**KIRKLEES METROPOLITAN COUNCIL
INVESTMENT & REGENERATION SERVICE**

DELEGATED DECISION TO DETERMINE PLANNING APPLICATIONS

Reference No: 2020/62/93103/W

Site Address: 27, George Avenue, Birkby, Huddersfield, HD2 2BD

Side Elevation

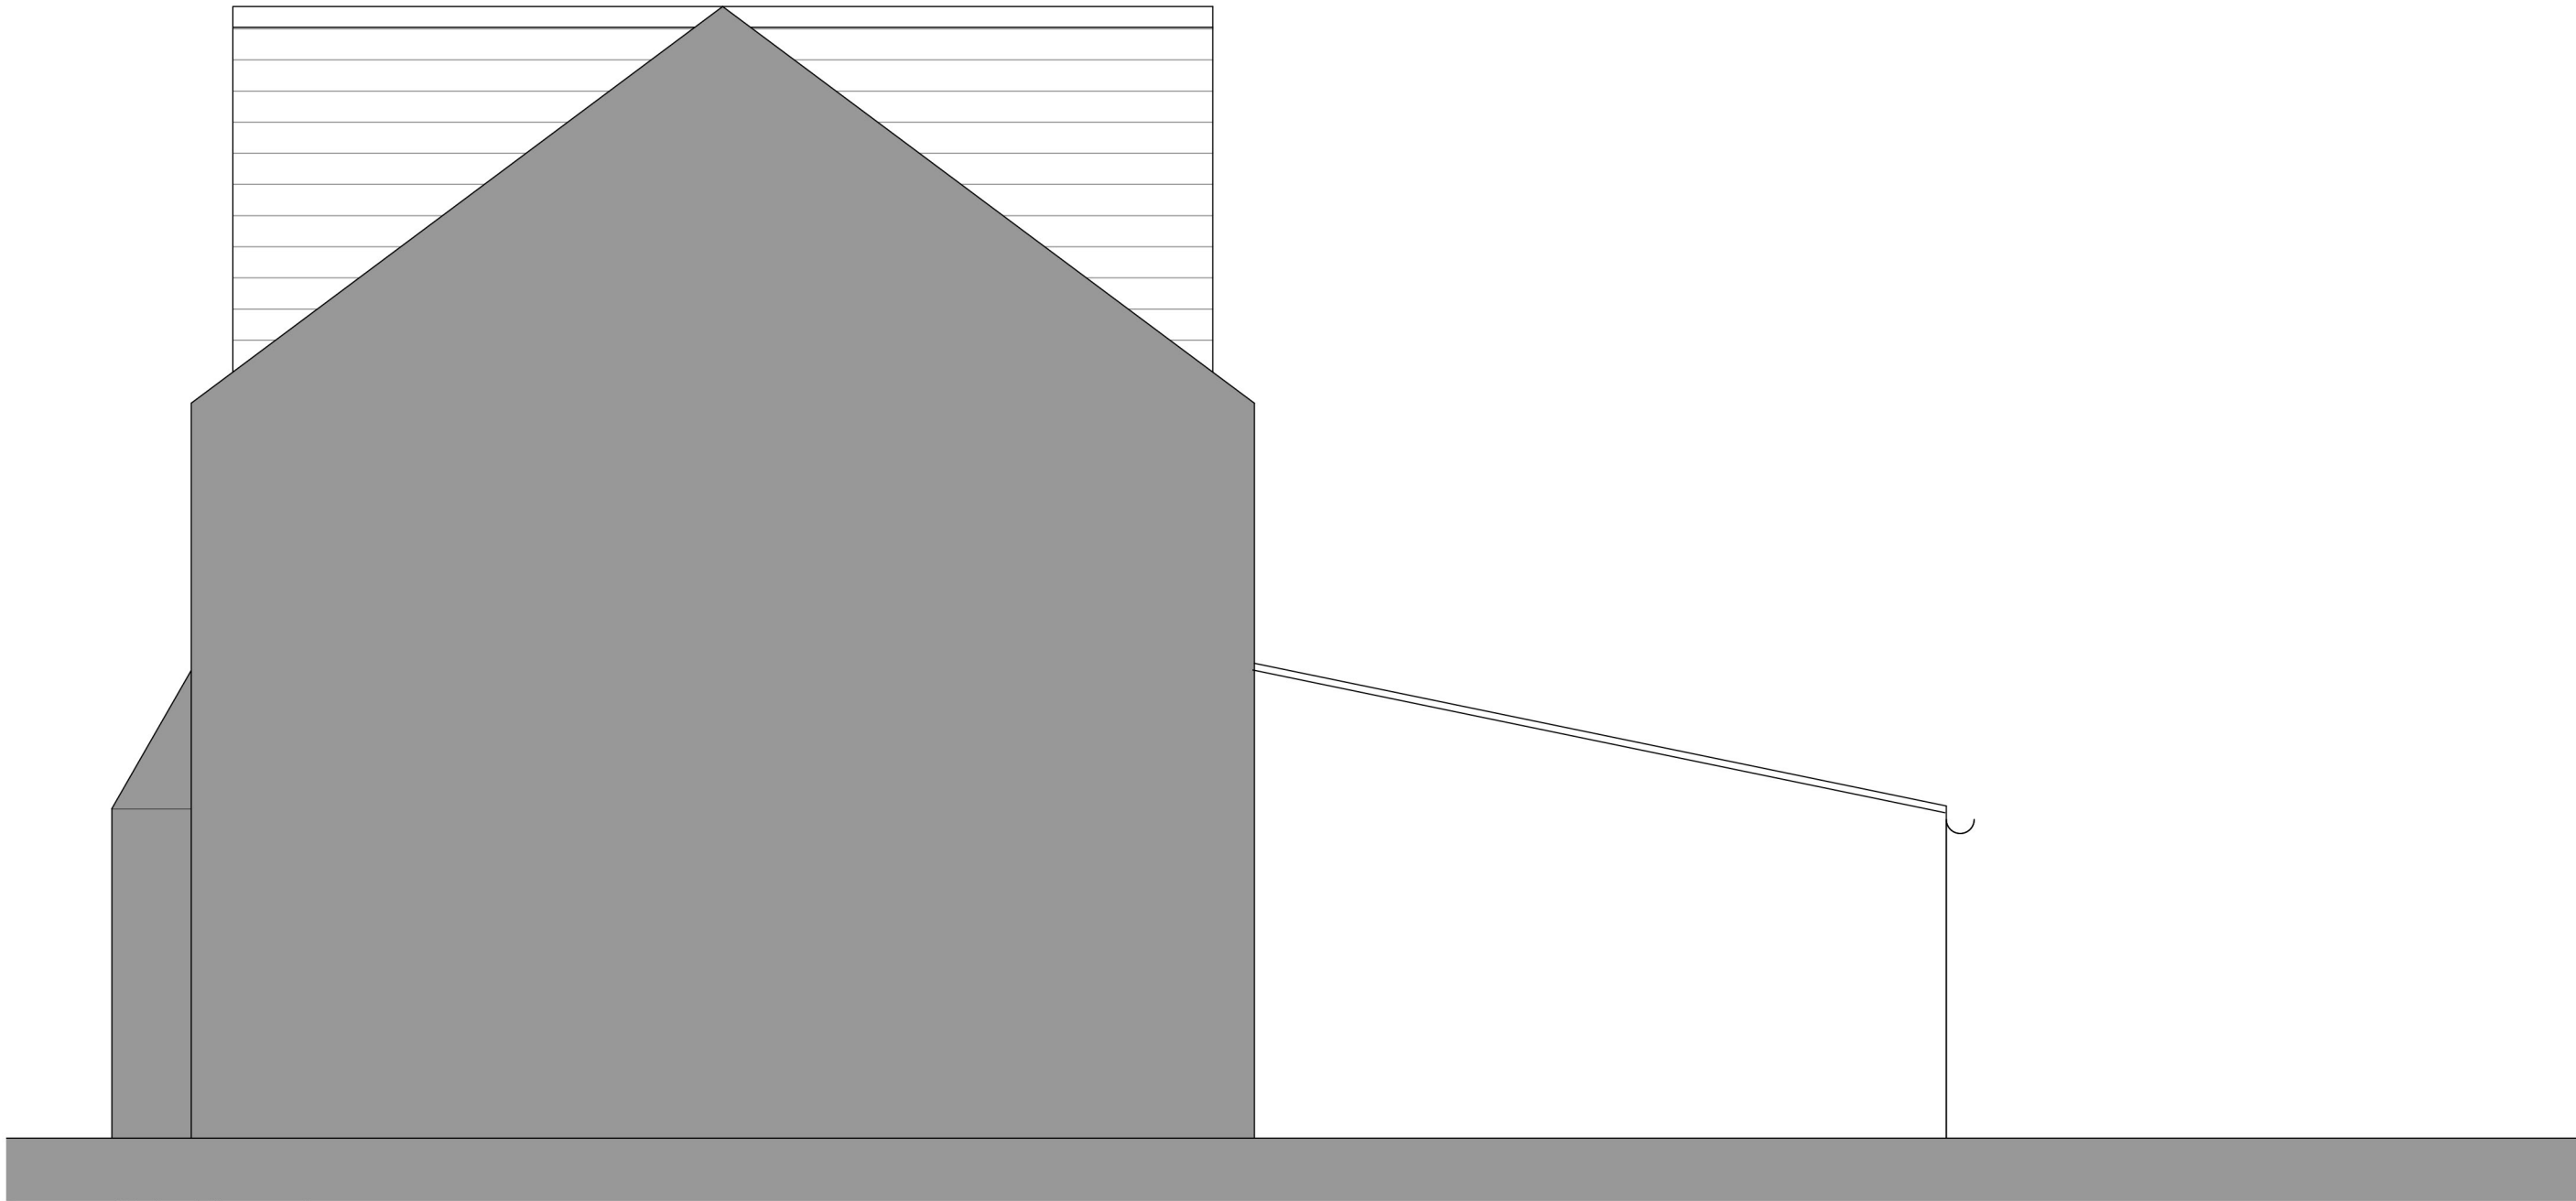
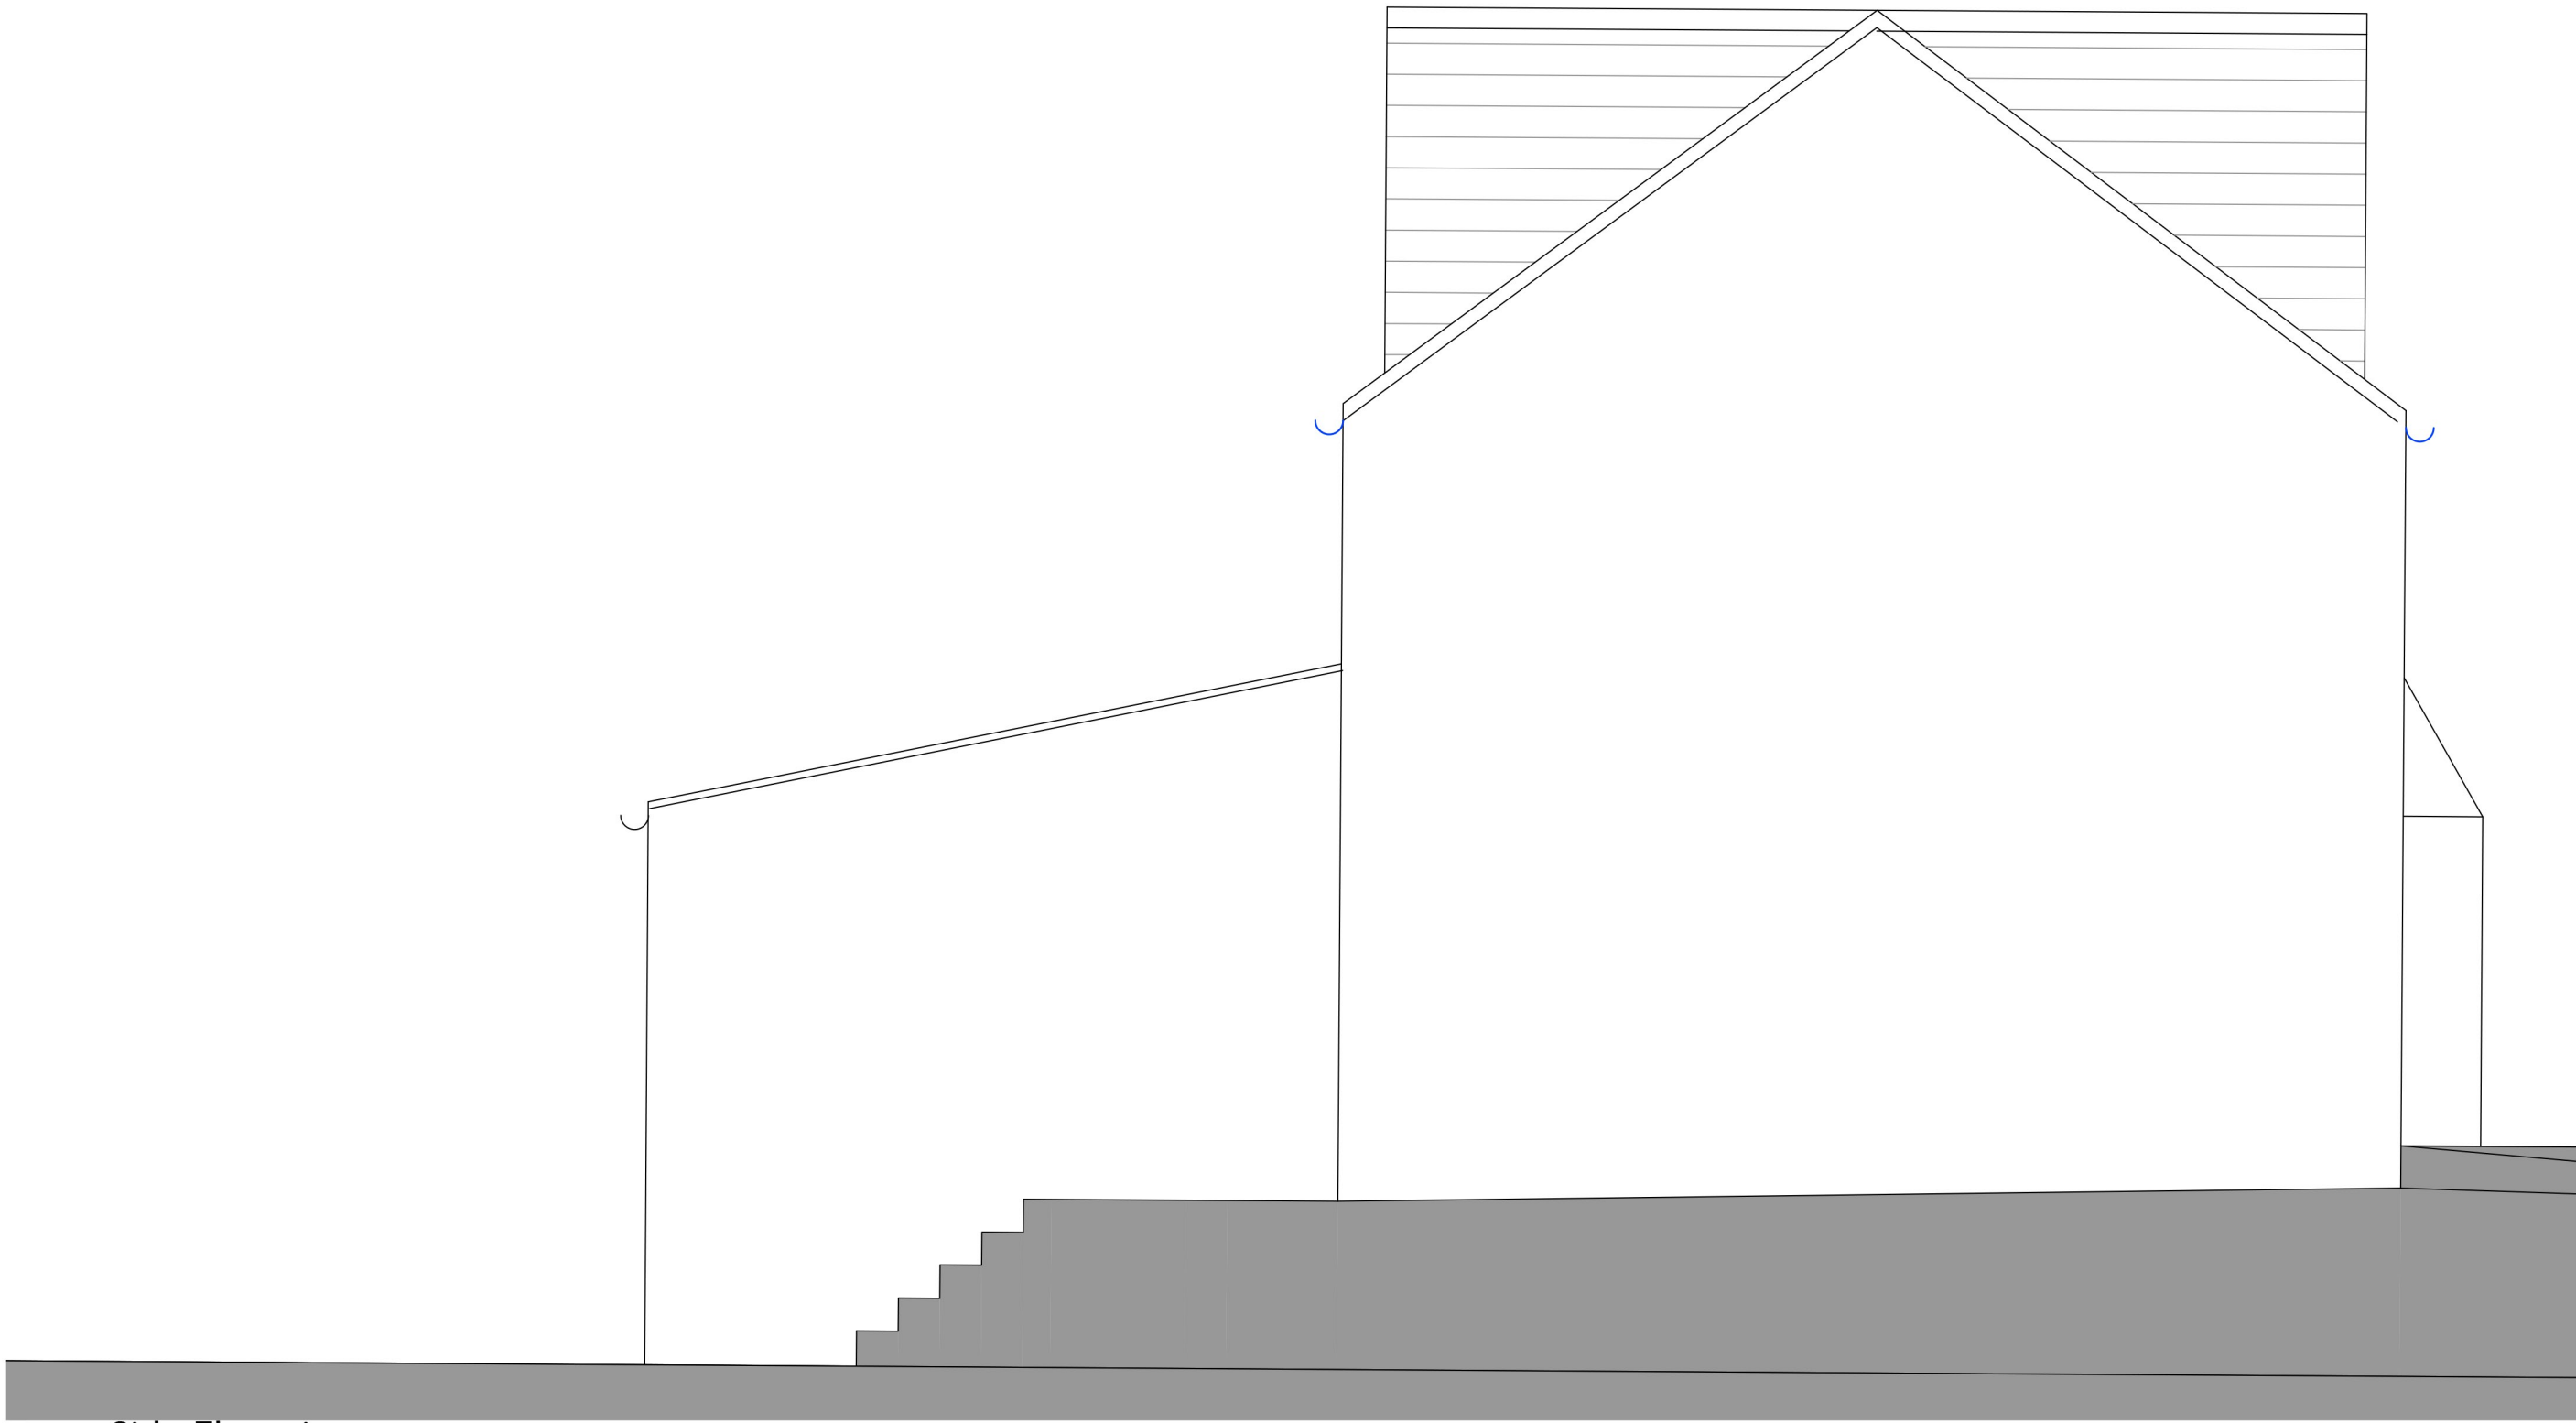
In this case, it has been considered that the proposed extensions would appear subservient to the host property, as the rear extension would be retained at single storey with a shallow lean to roof. The alterations to the existing roof form from hip to gable will also ensure that the overall height of the property is not increased as part of this proposal. Concerns have been raised regarding the size of the front dormer and therefore amendments have been received. The rear dormer would also be set up from the eaves.

29 George Avenue is the attached property to the West of the application site. It has been considered that there would be some additional impact upon the amenity of these neighbours, given the works proposed. However, officers have noted that the rear extension would be retained at single storey with a shallow lean to roof. Amendments have also been sought to reduce the projection from 5m to 4m, which will also help alleviate some of the bulk and massing. As such, any overbearing is not considered to be undue.

With regards to overshadowing, any impact would only be evident within a morning and therefore can be supported. The submitted plans also show no additional openings to be inserted into the western facing side elevation, which will help protect these neighbour's private amenity space from any

There would also be no further impact on these neighbour's amenity, as a result of altering the existing hipped roof into a gable, as the submitted plans show the overall roof height to be retained as existing.

Front Elevation

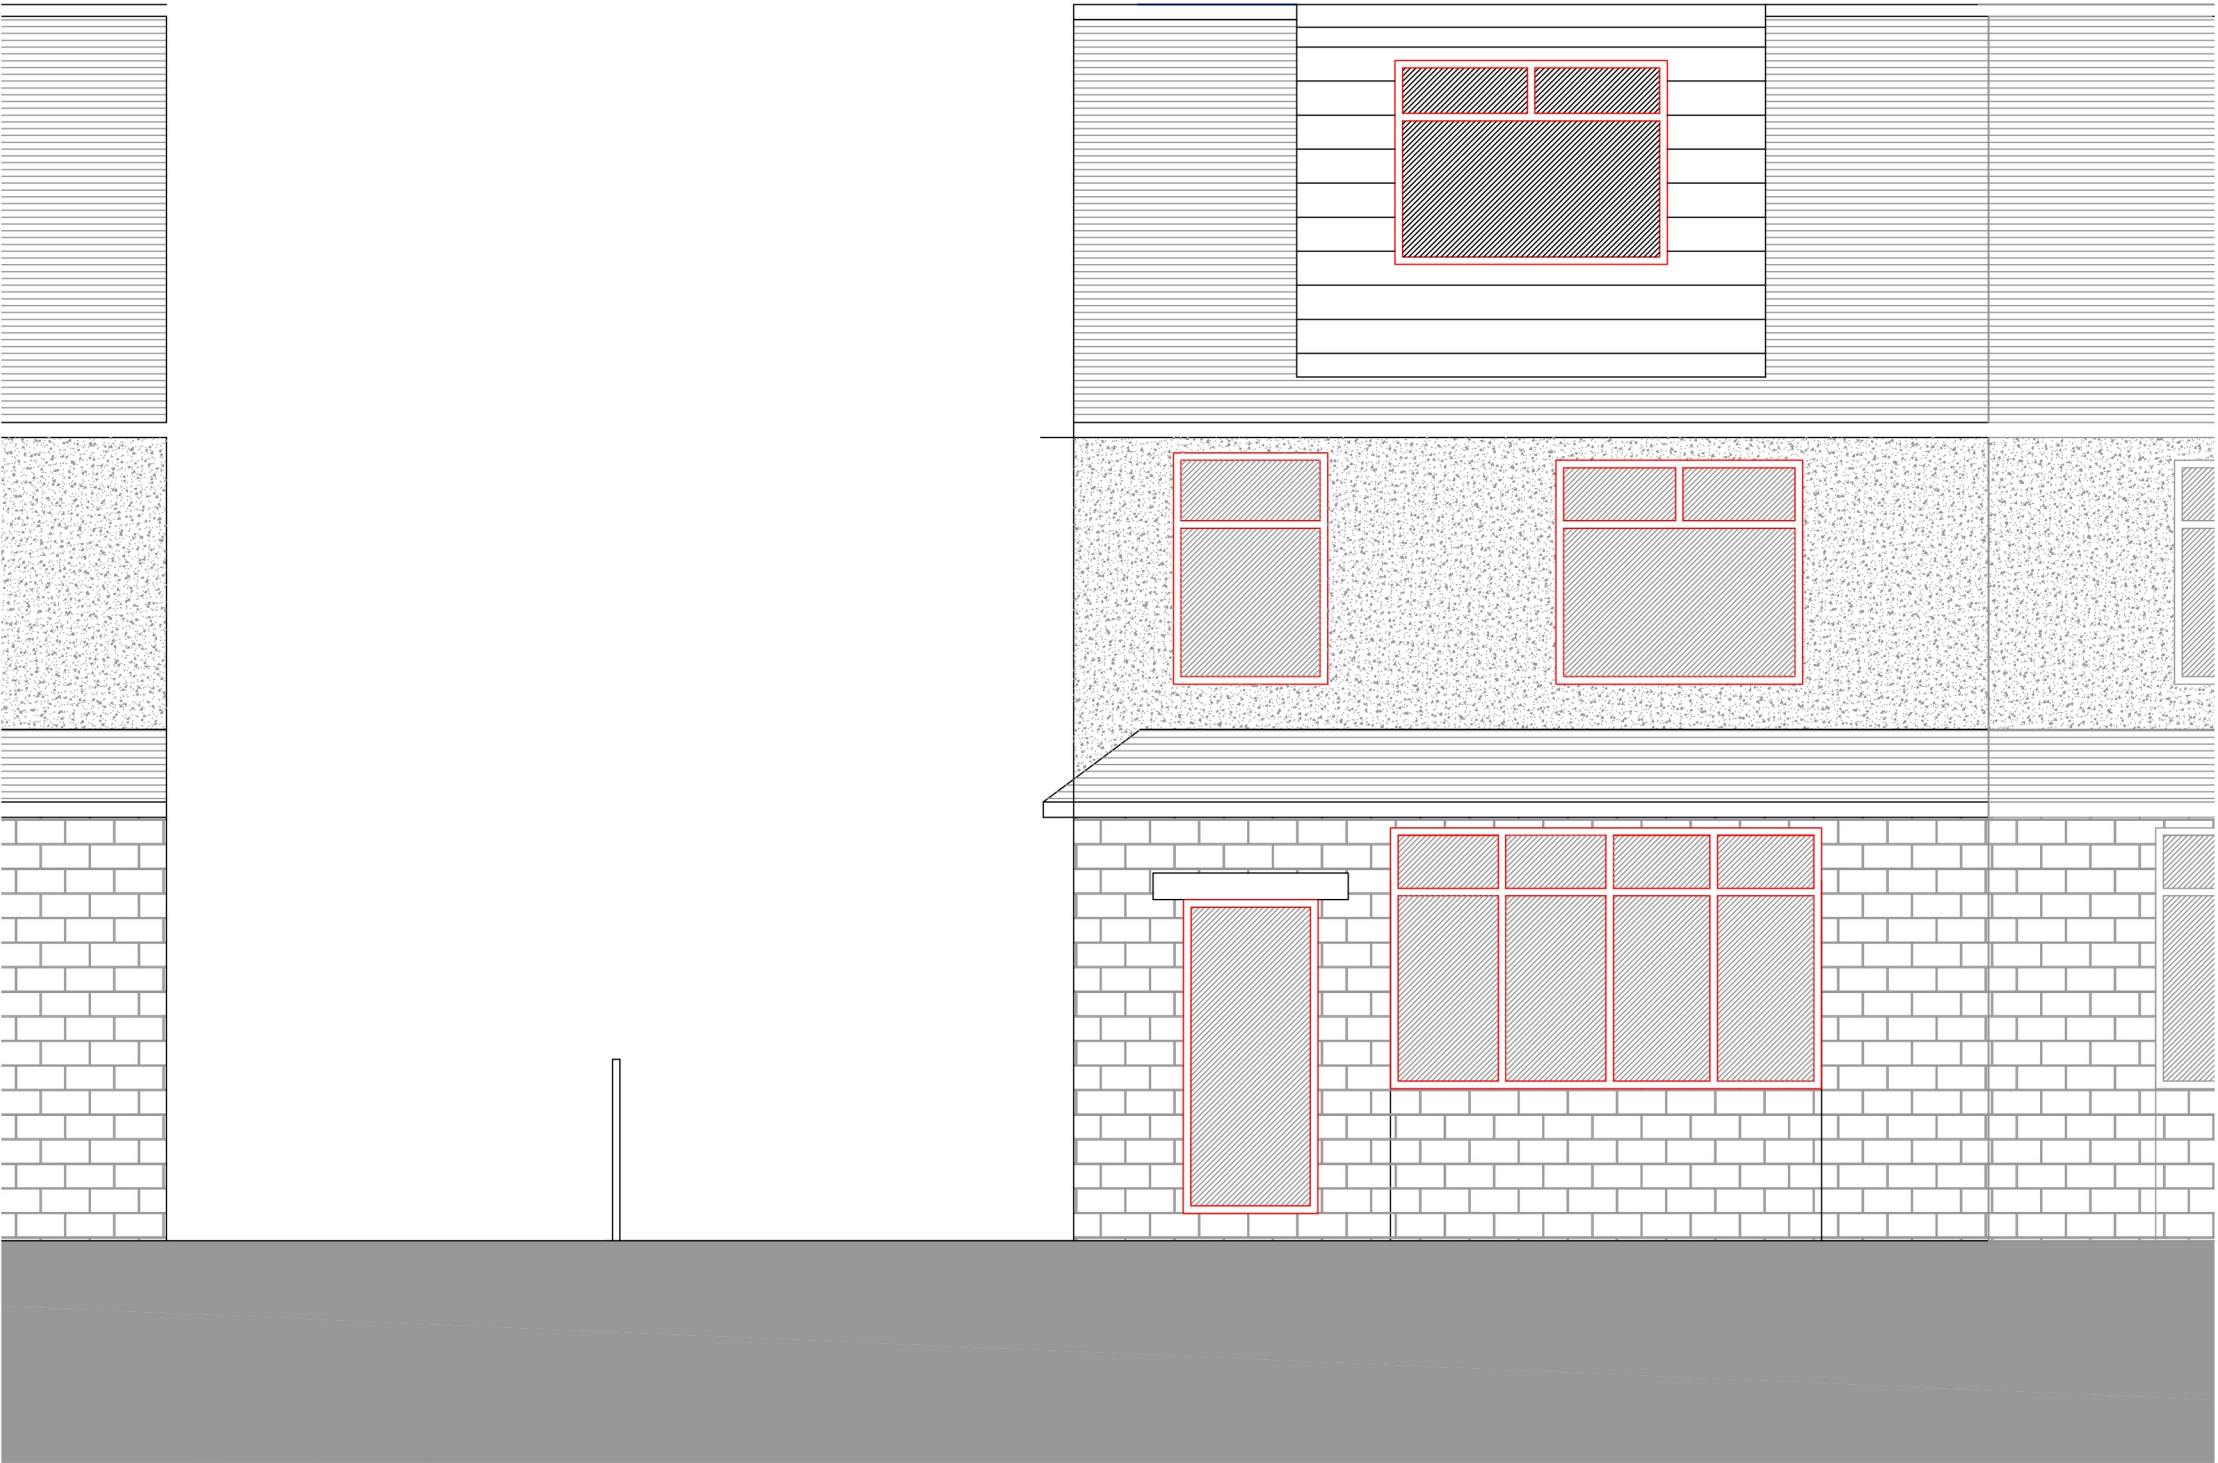
The design of the rear extension has been considered acceptable, as the development on balance would appear relatively small in size and scale when compared against the backdrop of the two storey property. Amendments have also been sought to reduce the projection of the extension from 5m to 4m, which will also help alleviate some of the bulk and massing. The submitted plans show the works to be constructed from stone, in which will match the stonework used on the host property.

In terms of fenestration, a rectangular window will be inserted into the rear elevation. This has been considered acceptable, as it will sit above the kitchen units. Double doors will be inserted into the rear elevation in order to provide a flexible space for the occupants. The submitted plans also show three roof lights to be inserted into the lean to roof, in which will allow more natural light penetration into the open plan kitchen. No new windows will be inserted into either side elevation.

It has been assessed that the rear dormer would appear relatively large in terms of its size and scale, and therefore has been designed based on function rather than form. Amendments have also been sought to reduce the size and scale of the front dormer, with officers also suggesting that the addition is situated above the existing bedroom window. However, given the internal layout of the roof space, the applicant wishes to keep the dormer within a central location, and therefore an on balanced decision has been made.

Both dormers would be set up from the eaves on the host property and would be finished in dark grey cladding. The use of this material has been considered satisfactory and therefore a condition will be attached to the decision notice accordingly.

Officers have entered into discussions with the agent regarding the overall projection of the single storey rear extension and the size of the front dormer. As such, amended plans have been sought in line with officers' recommendations. These were received on the 18th January 2021.
